Proposal:	Discharge of conditions 3 (phasing programme) 4 (surface water drainage scheme) 5 (drainage adoption plan) 6 (foul water drainage scheme) 7 (ecological wetland) 8 (detailed groundwork layout) 9 (details of lakeside structures) 12 (landscaping) 13 (construction method statement) and 19 (site access) of planning permission 3/2015/0426.
Location:	Pendle View Fisheries A59 Barrow BB7 9DH
Grid Ref:	374241 - 438293

The Highway Development Control Section has made the following comments regarding the discharge of conditions 3 (phasing programme), 13 (construction method statement) and 19 (site access): -

FIGURE 1 (REVISION B)
HIGHWAY & PEDESTRIAN ACCESS IMPROVEMENTS
AT AS9 AT PENDLE VIEW FISHERY
1.9.2015

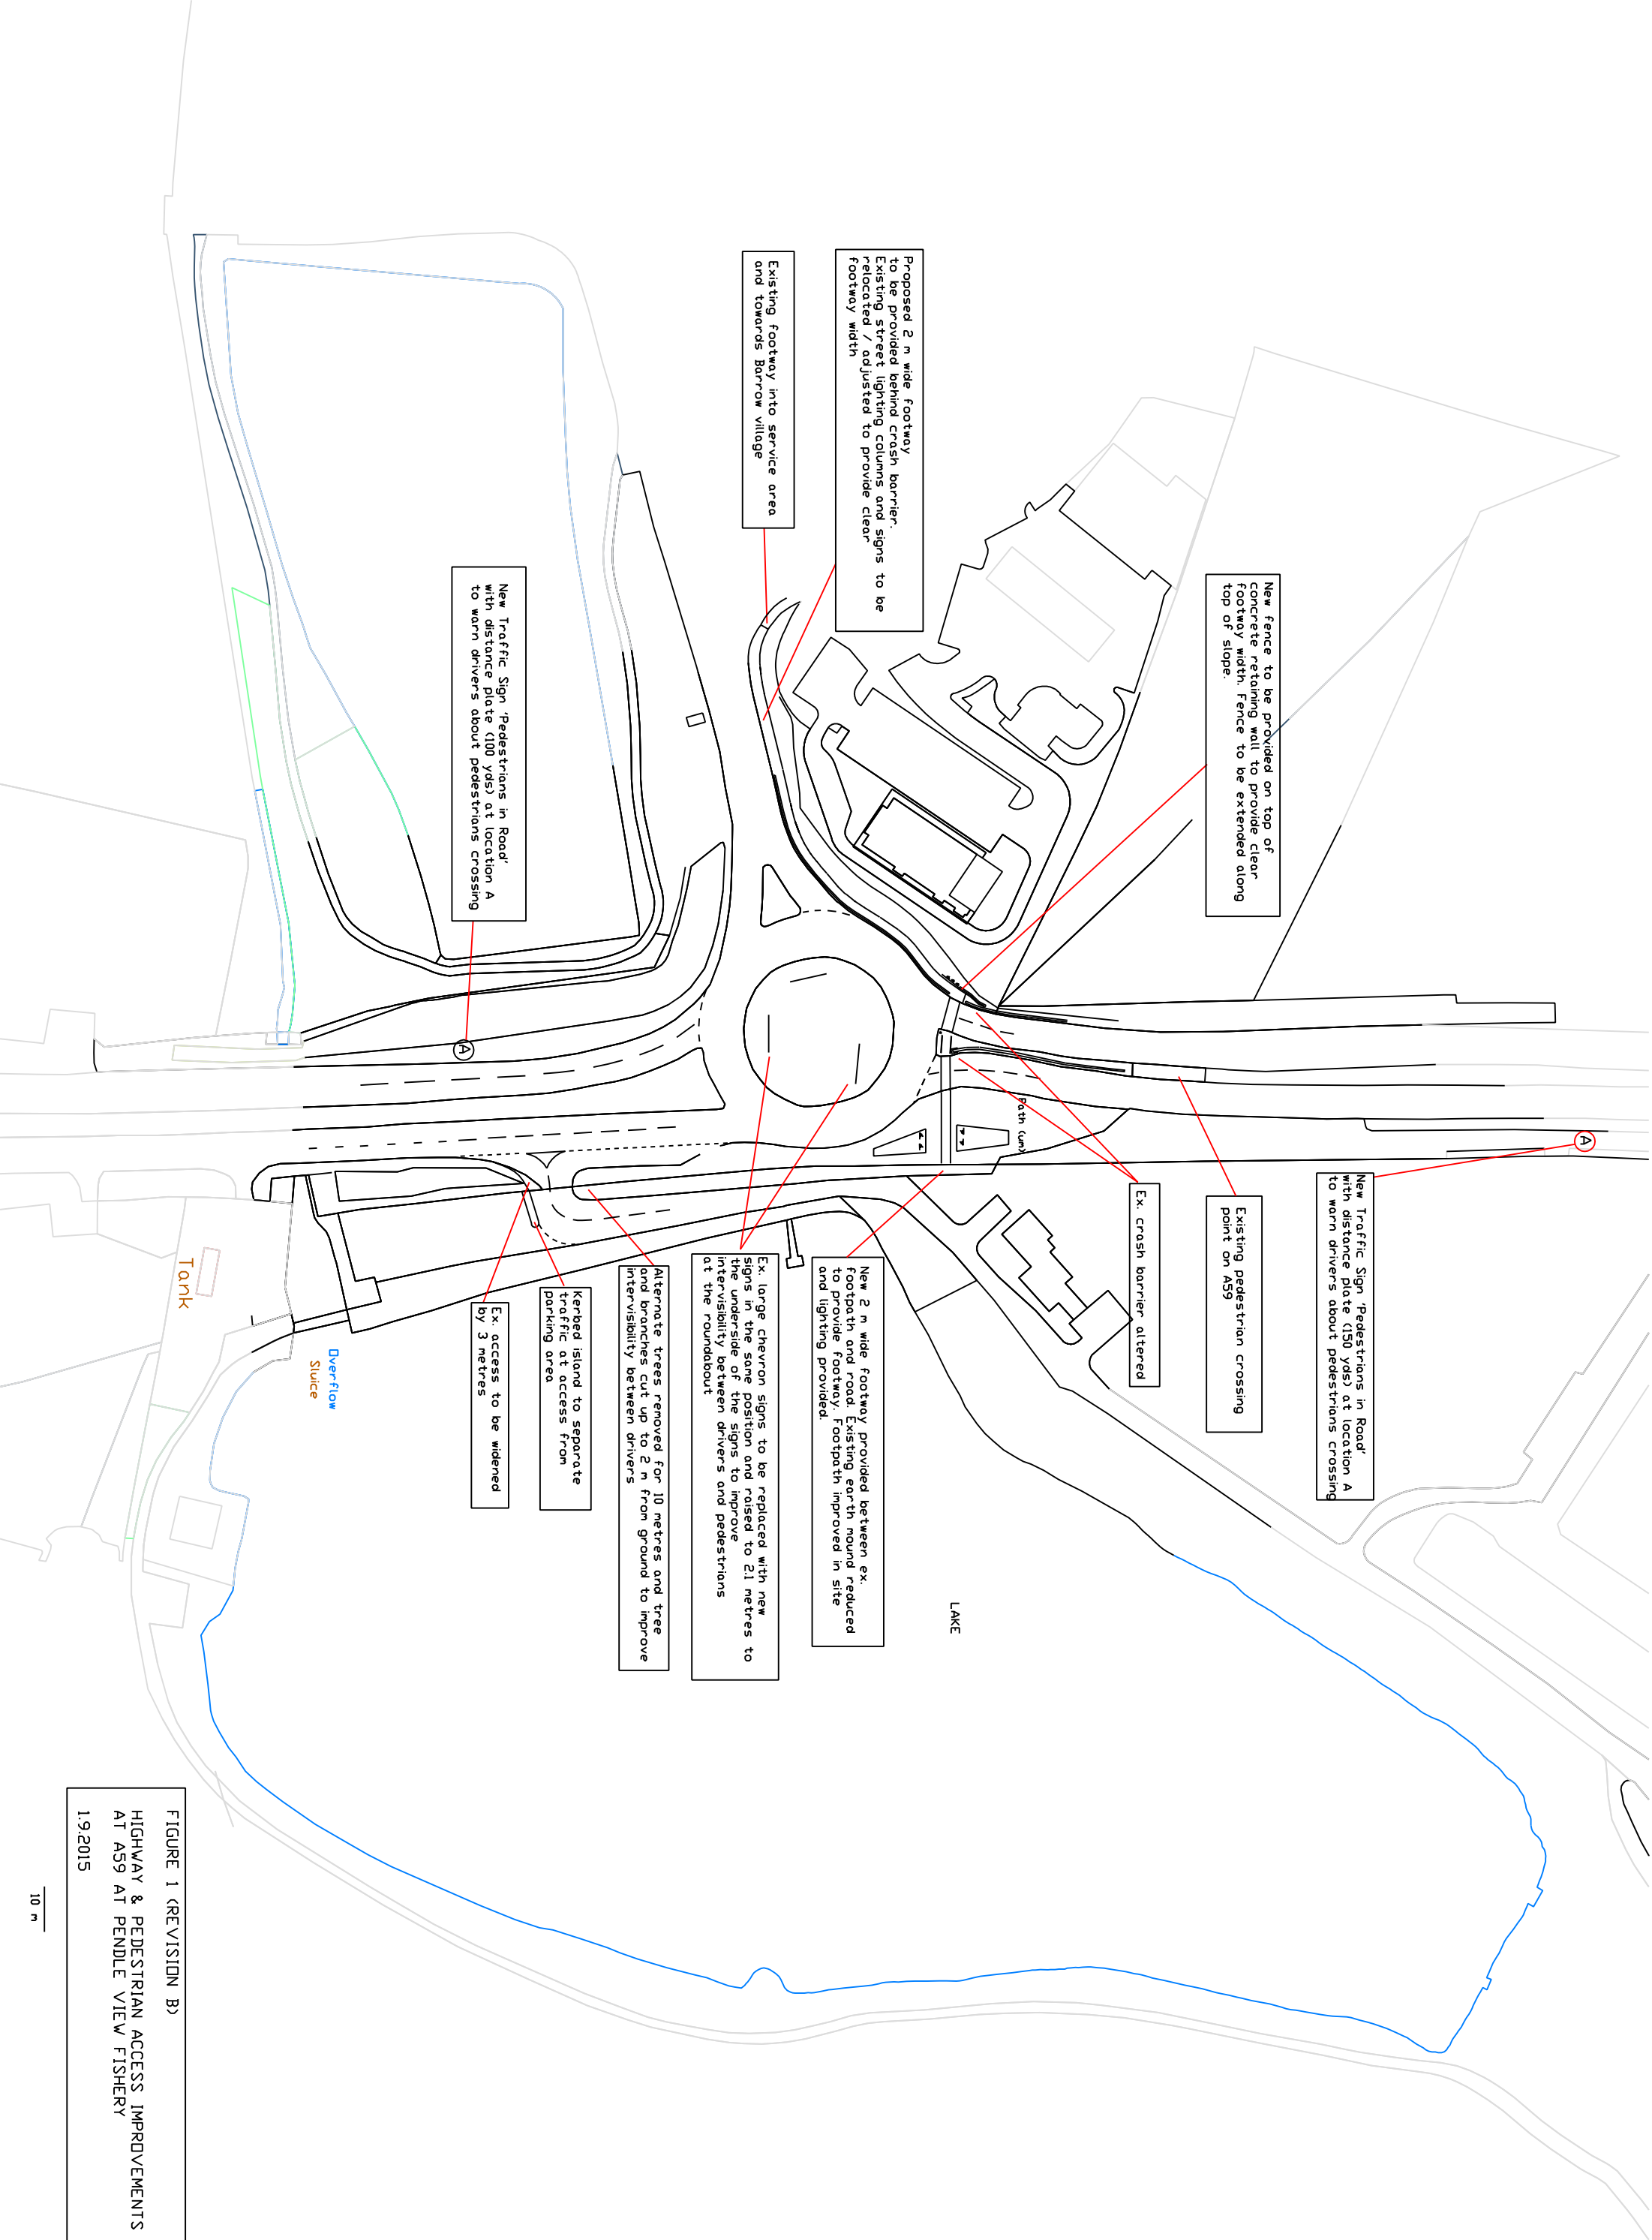
Condition 19 (site access)

The site access and off-site highway works to be carried out under a section 278 agreement with Lancashire County Council. Our section 278 officer has not been contacted regarding these works.

The new site access and associated off-site works will need to be constructed under a section 278 agreement of the 1980 Highways Act. The Highway Authority hereby reserves the right to provide the highway works within the highway associated with this proposal. Provision of the highway works includes design, procurement of the work by contract and supervision of the works. The applicant is advised to contact the Community Services before works begin on site. Further information and advice can be found at www.lancashire.gov.uk and search for 278 agreement.

Drawing Title
Phasing Plan

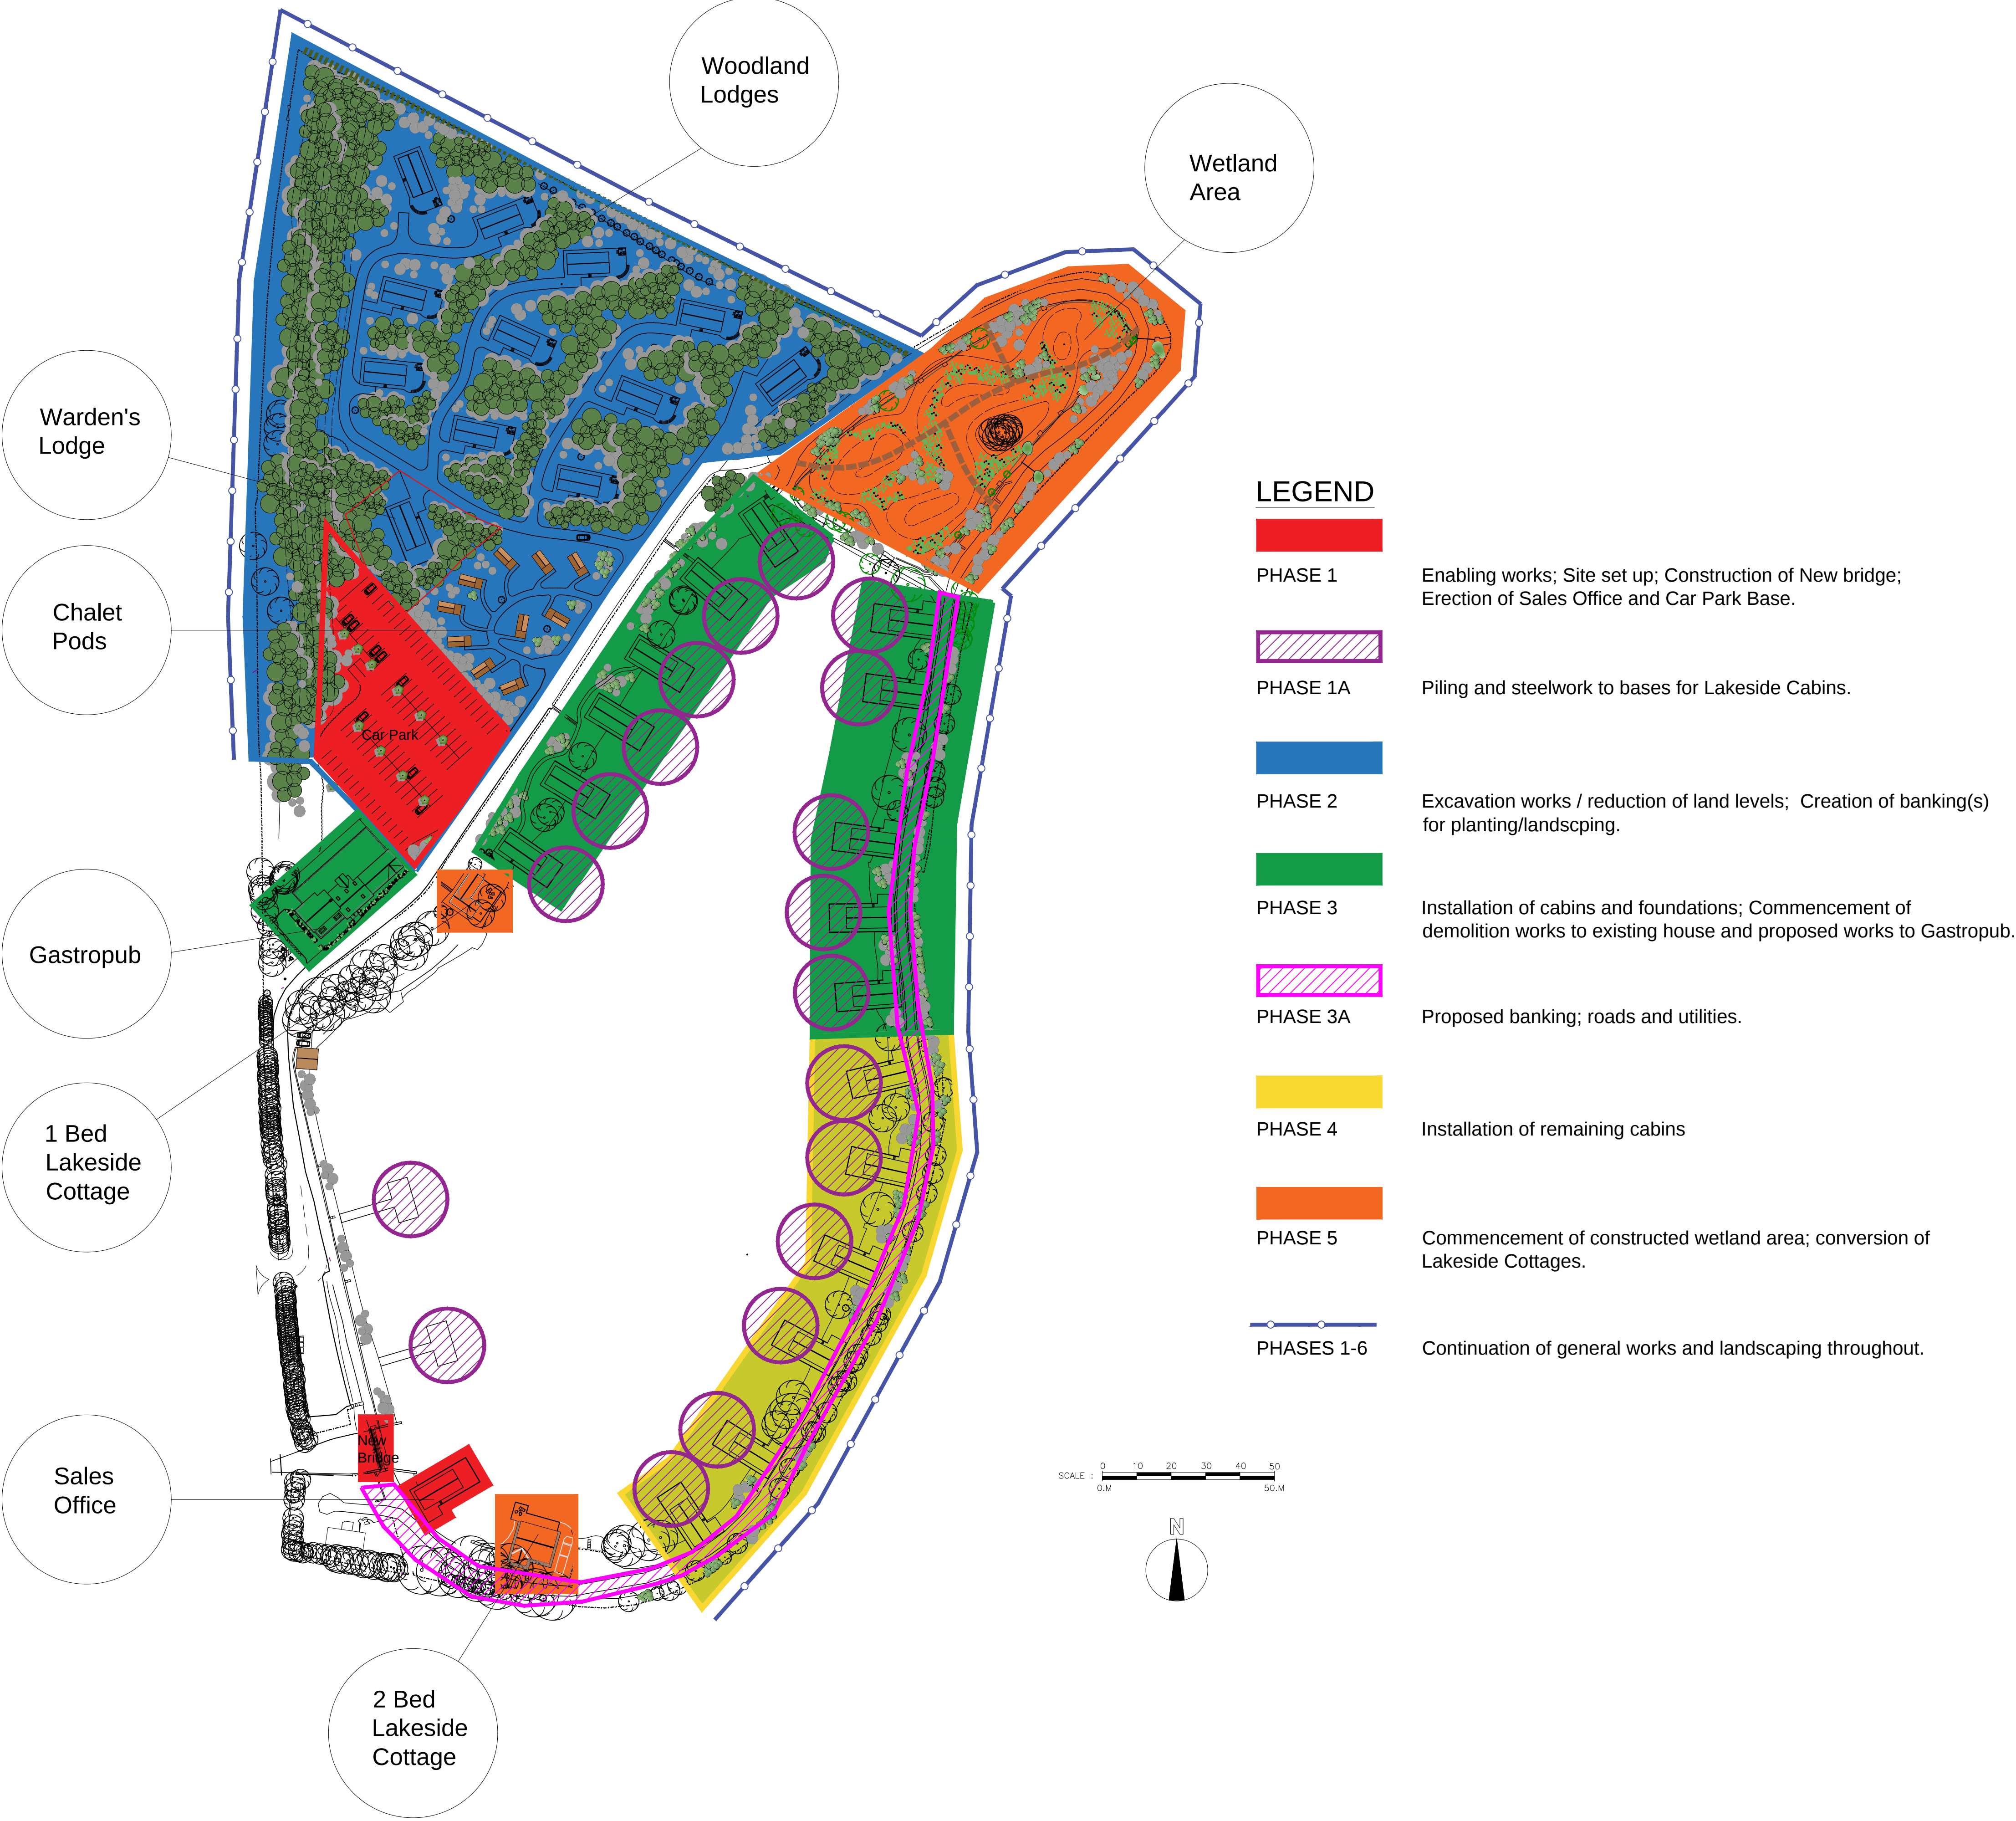
Condition 3 (phasing programme)

The site access and off-site highway works to be carried out under a section 278 agreement with Lancashire County Council. Our section 278 officer has not been contacted regarding these works.
